APPLICATION NO. 08 AA 10083	PROJECT NO. 1006801
PROJECT NAME Meridian Business Park II	
EPC APPLICATION NO.	
APPLICANT / AGENT Clavelis Vigil Architects	PHONE NO. 842-1113
ZONE ATLAS PAGE S-10	
(SDP for SUB), (SDP for BP), (FINAL PLATS), (MASTER DEV PLAN), (IR), (AA)	
ONE STOP COMMENT FORM LOG

DRB CASE ACTION LOG (SITE DEVELOPMENT PLAN) BP

DRB Application No.: 07DRB-70240 (SDP)	Project # 1006801
Project Name: BRUNACINI AT ATRISCO BUSINESS PARK	
Agent: CLAUDIO VIGIL ARCHITECTS	Phone No: 842-1113

DEVELOPMENT REVIEW BOARD – SPEED MEMO

SHEET NUMBER
C-101

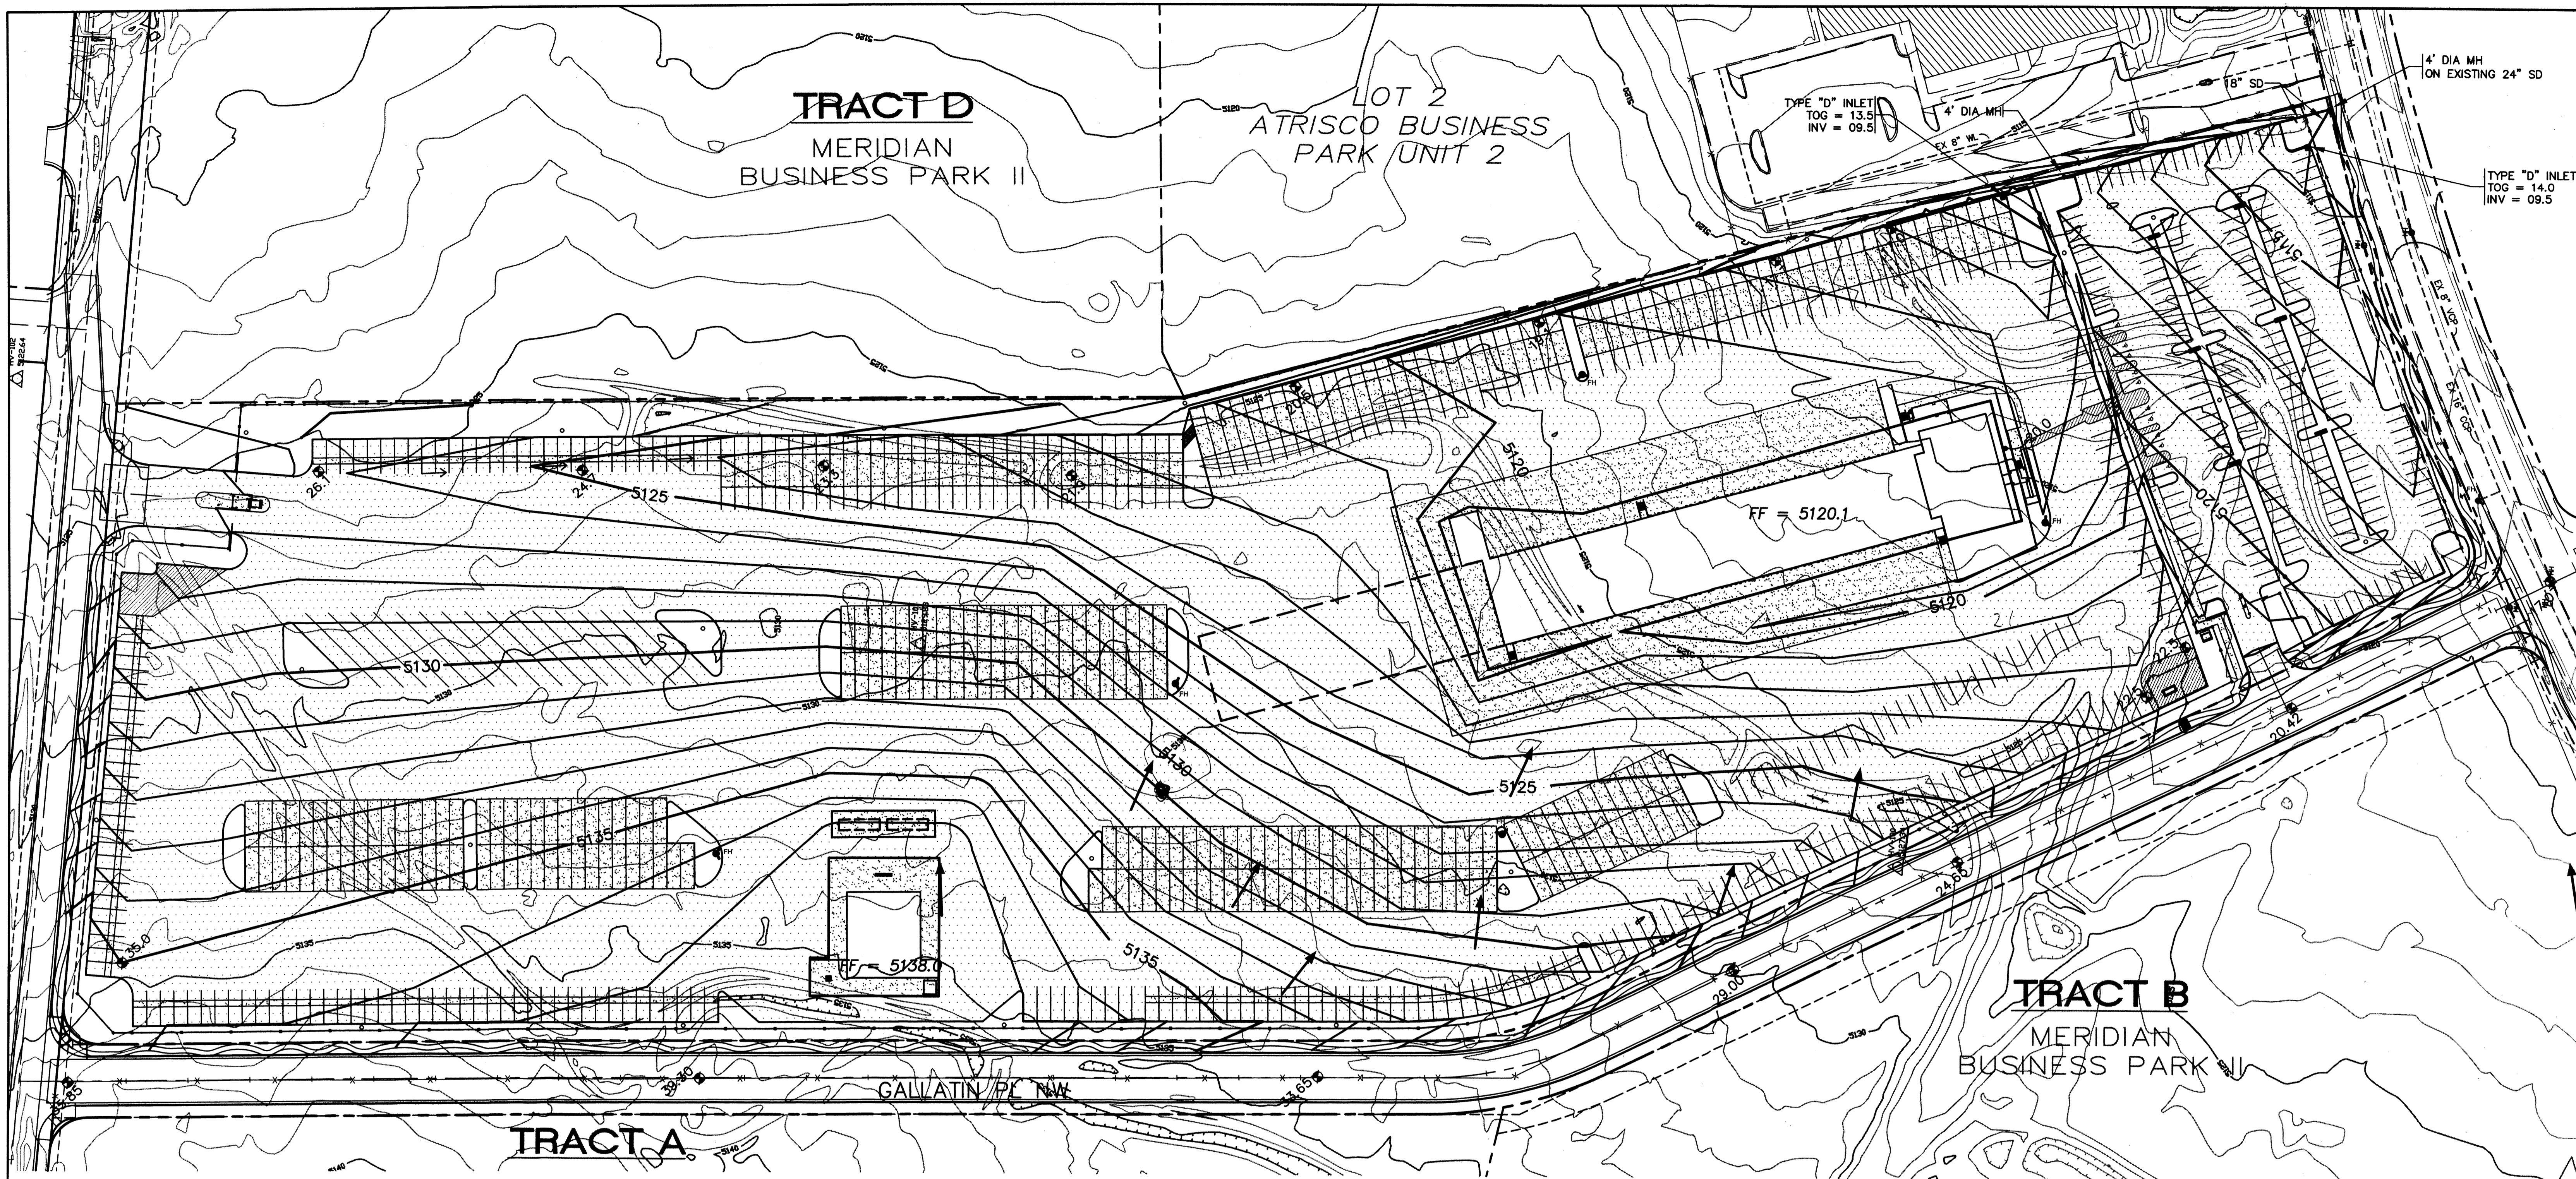
An approved SIA with Financial Guarantee(s) is required prior to site plan approval.
Show the pond location on the plan.

Infrastructure List comments.
Concurrent platting action is required.
An approved SIA with Financial Guarantee(s) is required prior to site plan approval.
Note: Discharge is limited to 0.1 cfs / acre. Ponding will be required.
Show the pond location on the plan.
